# **REPORT on the IMPLICATIONS for EUROPEAN SITES**

## **Proposed Peartree Hill Solar Farm**

Planning Inspectorate Reference: EN010157

07 November 2025

Figure 12.3: Baseline Noise Monitoring Locations

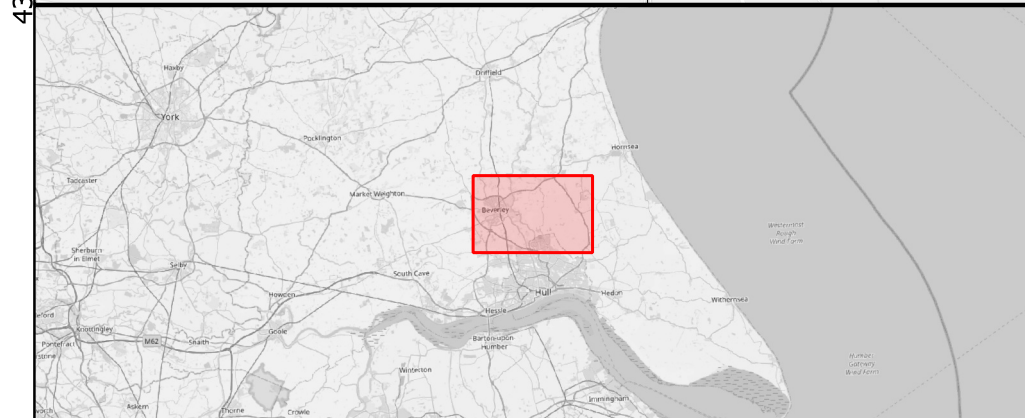
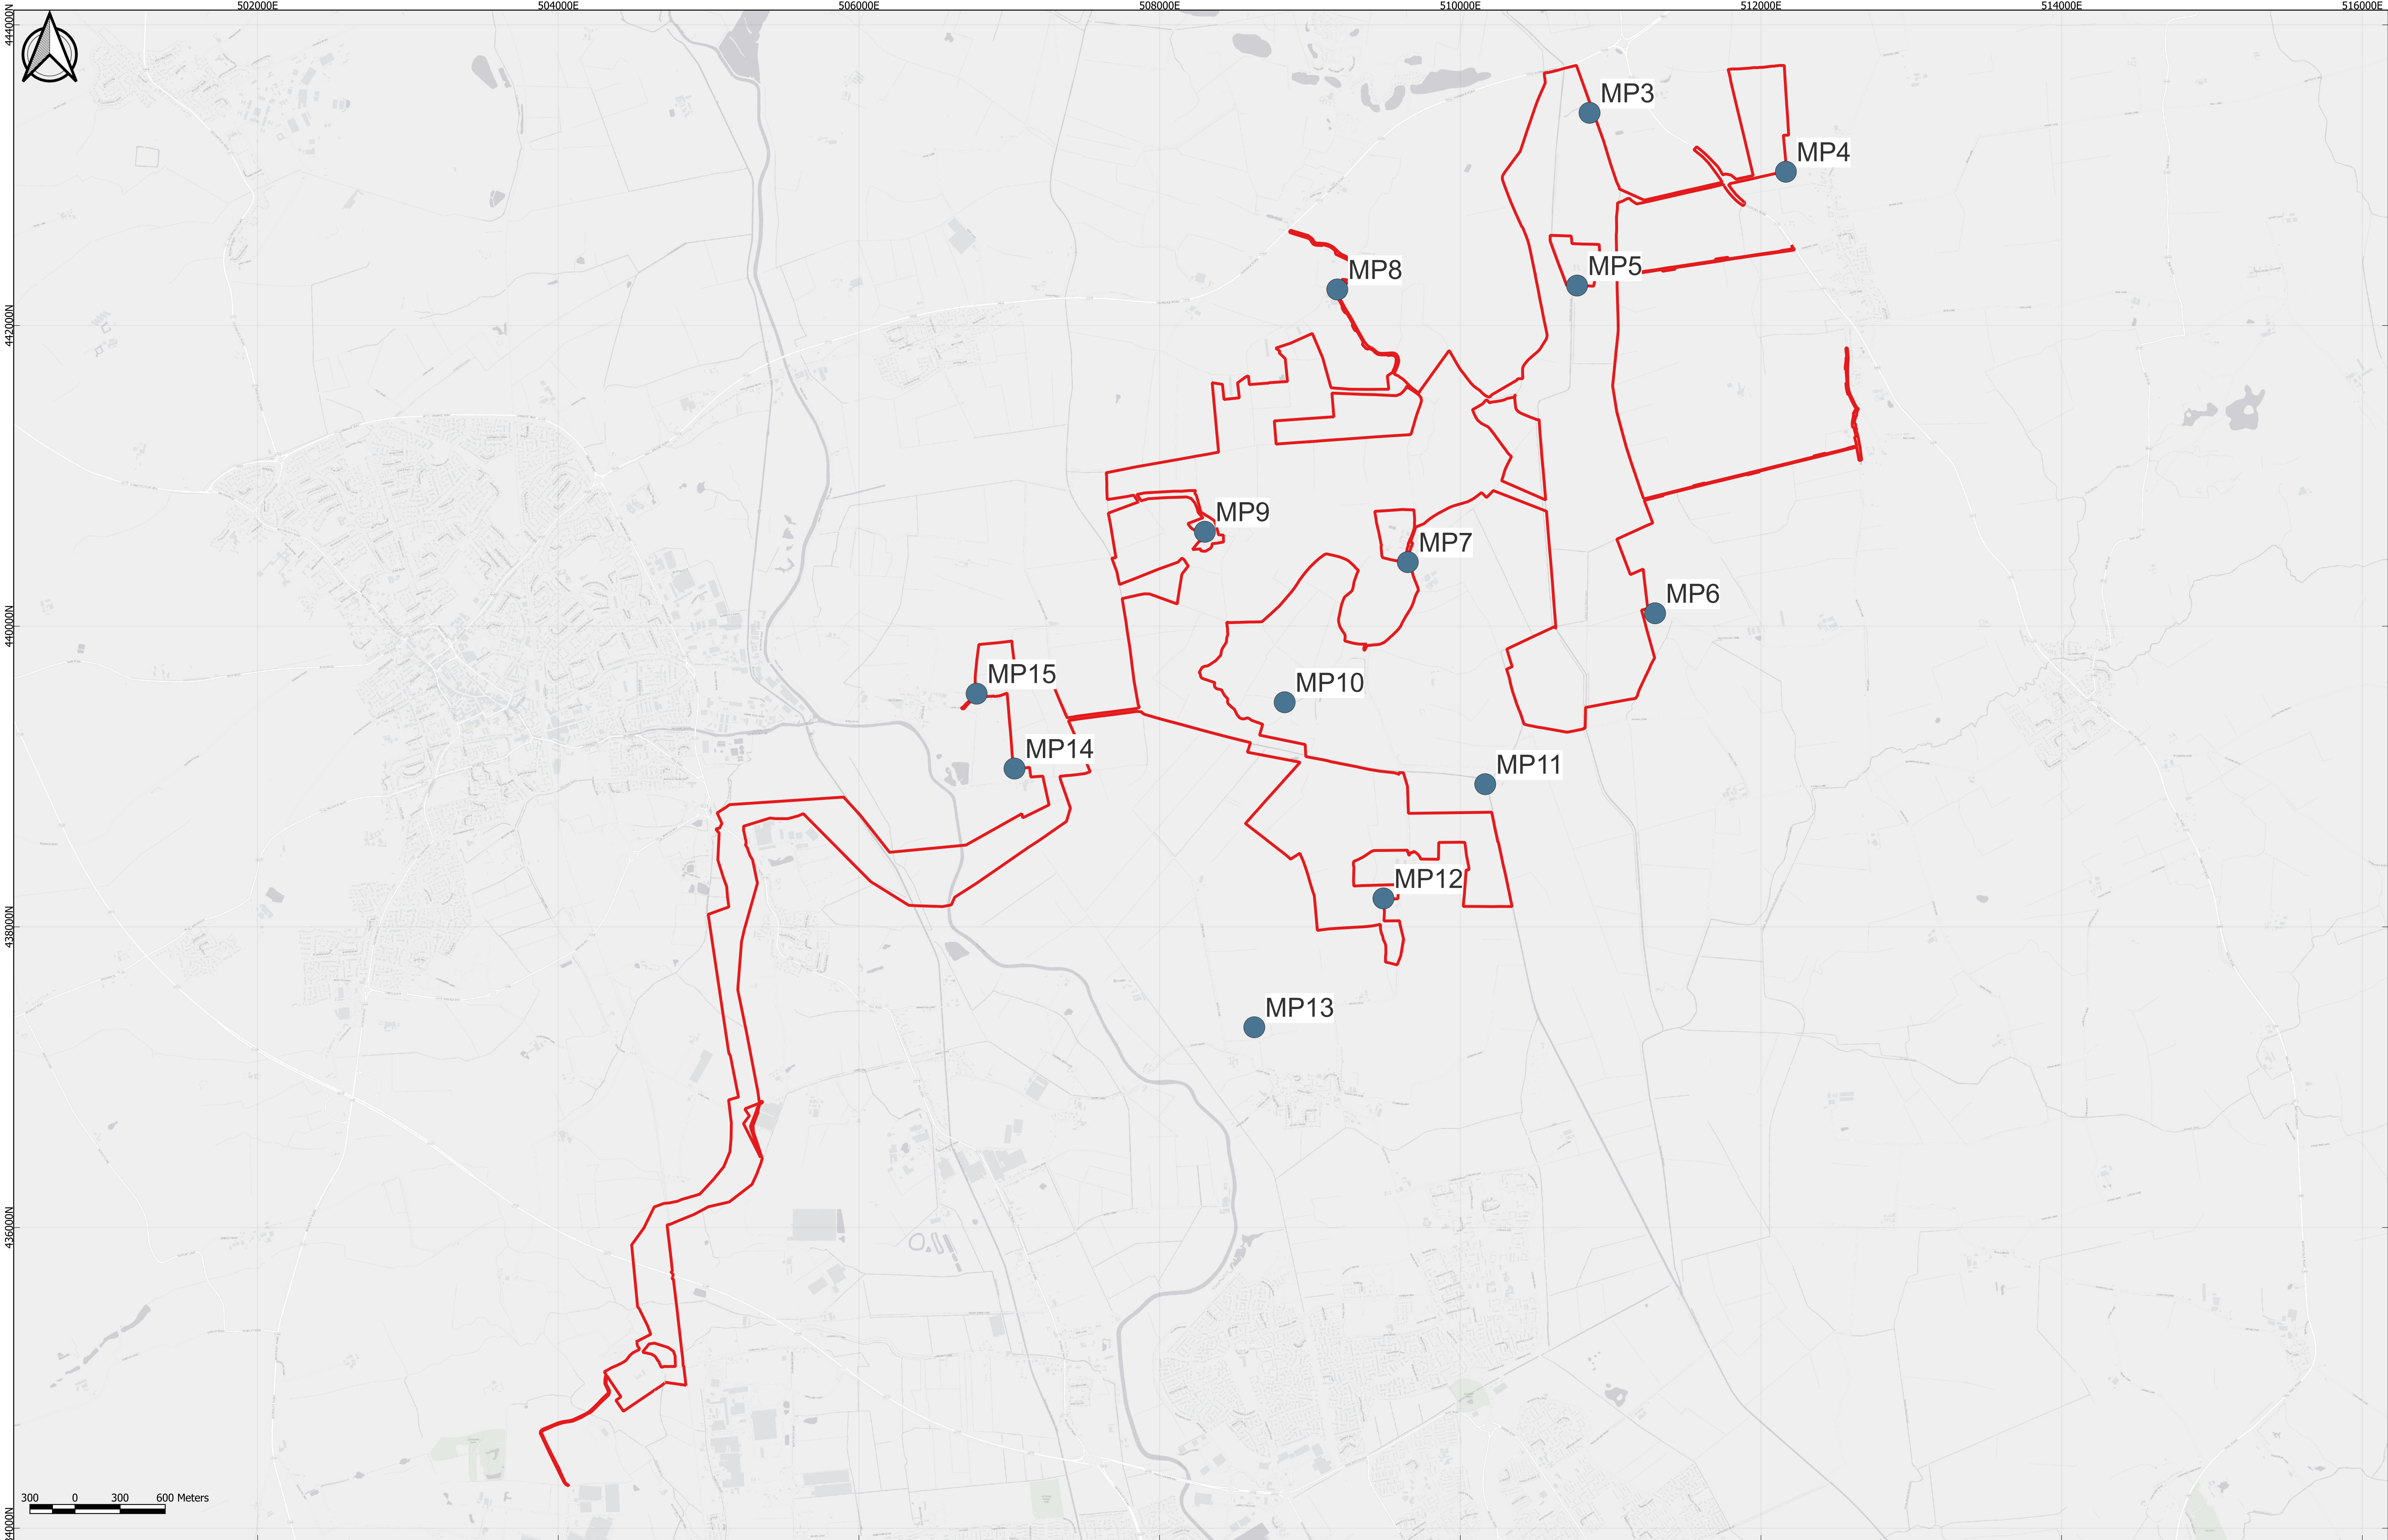
3.1.7	Potential noise and visual disturbance	NE [RR-012] advised that the HRA should set sensitive receptors in the context of the existing noise environment and recommended further assessment regarding the predicted location of 'noisy' works in	n/a – matter resolved

impacts to FLL - construction	<p>the context of the bird survey results, to identify whether disturbing noise levels from the development will reach land utilised by birds in significant numbers. NE advised that when interpreting noise assessment results, it does not propose specific thresholds for determining when an impact will occur and described the relevant factors which should be considered together. NE recommended that suitable mitigation should be explored for predicted noise levels above 50dB.</p> <p>NE made recommendations on potential mitigation measures and advised that an assessment should be provided of the predicted reduction in noise levels that will occur as a result of the proposed mitigation measures, to assess their effectiveness.</p> <p>The applicant [REP-071] detailed that it would avoid completing the activities most likely to disturb birds during winter (October to March) and only activities less likely to disturb birds would take place in fields adjacent to the Humber Estuary designated sites. If this is not possible, acoustic fencing would be installed for the construction period. The HRA Report [REP1-015] and oCEMP [REP1-050] were updated to secure these commitments. The oCEMP was also updated to include a commitment relating to no night-time working (unless agreed with the LPA) and keeping any artificial light to a minimum.</p> <p>EYRC [REP1-086] advised that with regard to noise disturbance the HRA Report makes an assessment on guidance that NE does not support and that construction impacts such as noise and visual disturbance should be considered up to 300m from source and assessed in consideration of baseline scenarios.</p> <p>The ExA [PD-014] requested that the applicant confirm whether the assessment is based on guidance supported by NE. The applicant [REP3-040] acknowledged that consultation with NE indicates concern regarding the use of the Waterbird Disturbance and Mitigation</p>

<p>Toolkit but stated that the assessment has not relied on information provided in this guidance and the applicant's response sets out how a precautionary approach has been undertaken regarding noise and disturbance.</p> <p>NE [REP2-154] stated that consideration of noise and visual disturbance to the mitigation areas is now resolved but reiterated the remaining outstanding matters recorded above.</p> <p>The applicant [REP3-039] provided further context on the bird survey results and the pattern of bird activity within and adjacent to the order limits, including the grid connection cable route. The HRA Report [REP3-014] was amended to clarify that the measures included in the oCEMP [REP3-026] would be implemented to mitigate the effect of disturbance/ displacement of relevant bird features of the Humber Estuary SPA and Humber Estuary Ramsar site within and adjacent to the order limits, including the grid connection cable route, as well as the mitigation areas. The applicant stated that it does not consider a requirement to undertake additional noise monitoring in relation to wintering birds is necessary given that no hotspots for birds were identified and considering the proposed mitigation measures.</p> <p>NE's D4 submission [REP4-084] confirmed that it considered all of the above matters to now be resolved based on the additional information provided. The draft SoCG [REP3-043] sets out that ERYC considers this point to now be resolved.</p>
